**KIRKLEES METROPOLITAN COUNCIL
INVESTMENT & REGENERATION SERVICE**

DELEGATED DECISION TO DETERMINE PLANNING APPLICATIONS

Reference No:	2021/62/94494/W
Site Address:	33, Foster Avenue, Crosland Moor, Huddersfield, HD4 5LN
Description:	Erection of two storey side and single and two storey rear extensions
Recommending Officer:	Ellie Worth

DECISION – Refused

Rev - : dd-mm-yyyy : Initial : Issue
Drawing Number 21-147 - P - 03

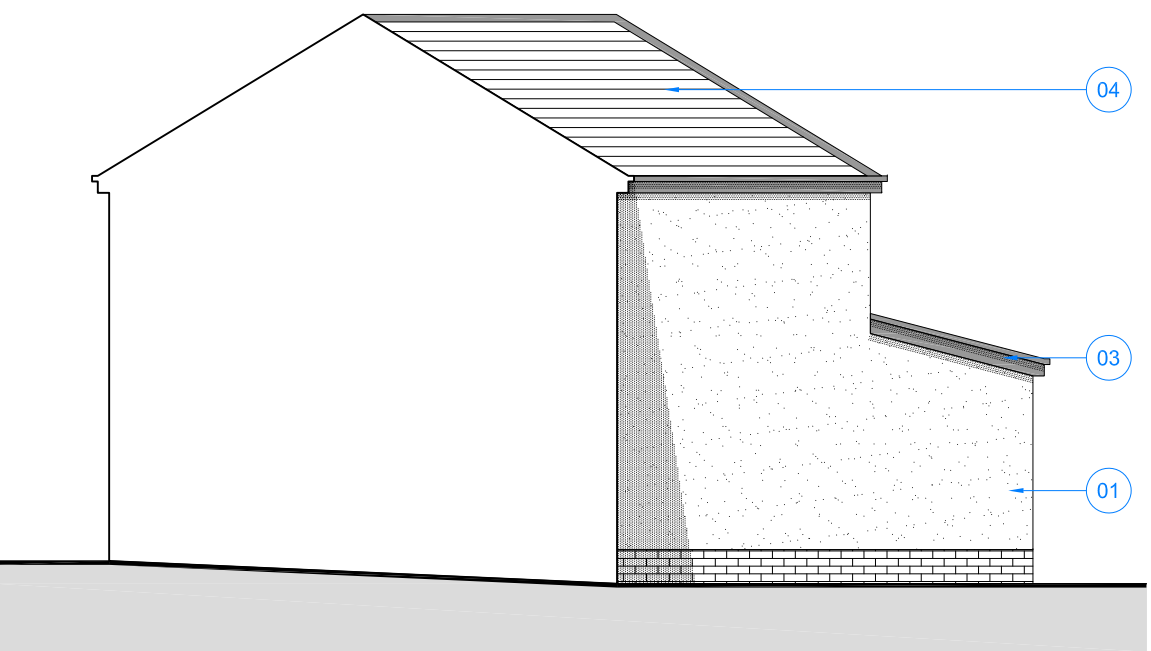
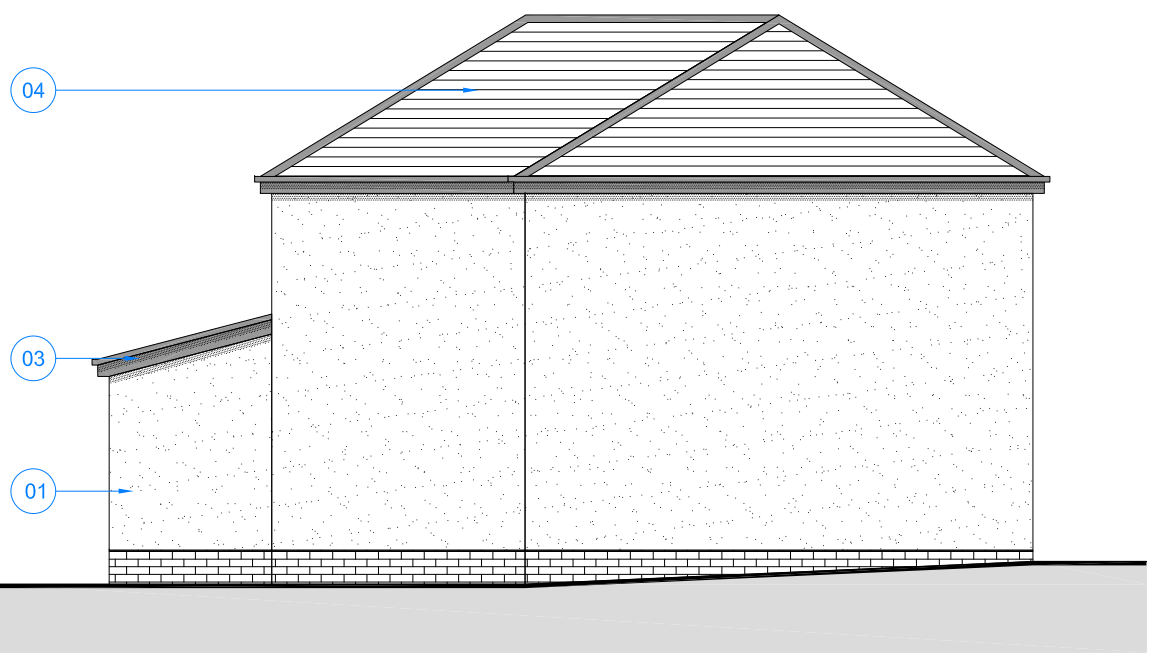
Whilst amendments have been undertaken as part of this modified scheme, to change the cat slide roof into a hipped roof, the additional bulk and massing would still fail to comply with paragraph 5.19 of the House Extensions SPD which states that “two-storey side extensions can have a significant effect on the character of the original house and the street. Adequate space between buildings should be retained to provide a sense of space which is important to the character of an area”. In this case, the amended street scene elevation shows a separation distance to the nearest boundary of 0.7m.

In this instance, the extension does not comply with the above and would appear as a continuation of the existing dwelling, taking away from its original

built form. This in turn has been considered undesirable as it would be out of character and would poorly relate to the attached property in which it is read alongside.

Therefore, in this case, it has been noted that the rear extension would be proportionate to the size of the dwelling, with the ground floor aspect falling under the remit of permitted development. At first floor, the works would have a projection of 3.3m which is slightly larger than what is outlined above, however, this has been reduced from 3.6m which was submitted as part of the previous application.

Nonetheless, the extension would only be inset from the nearest boundary by 0.1m and therefore would not retain an appropriate separation distance from the shared boundary. For these reasons, the works are not considered to comply with the aforementioned design principles.

27 Foster Avenue is the neighbouring property to the east of the application site. It has been considered that there would be a detrimental overbearing and overshadowing impact upon these neighbours amenity, given the fact that the property is a single storey bungalow, with what appears to benefit from,

habitable room windows in which overlook the application site. As such, the substantial bulk and massing contained within the side extension would have a material impact upon these neighbour's amenity.

Whilst amendments have been sought as part of this new proposal, to reduce the roof from a cat slide to a hip, this is not considered to overcome the concerns raised, as the main impact would be from the external walls. To add to the above, it has been noted that the application site is situated on a slightly higher level, given the changes in topography within the area.
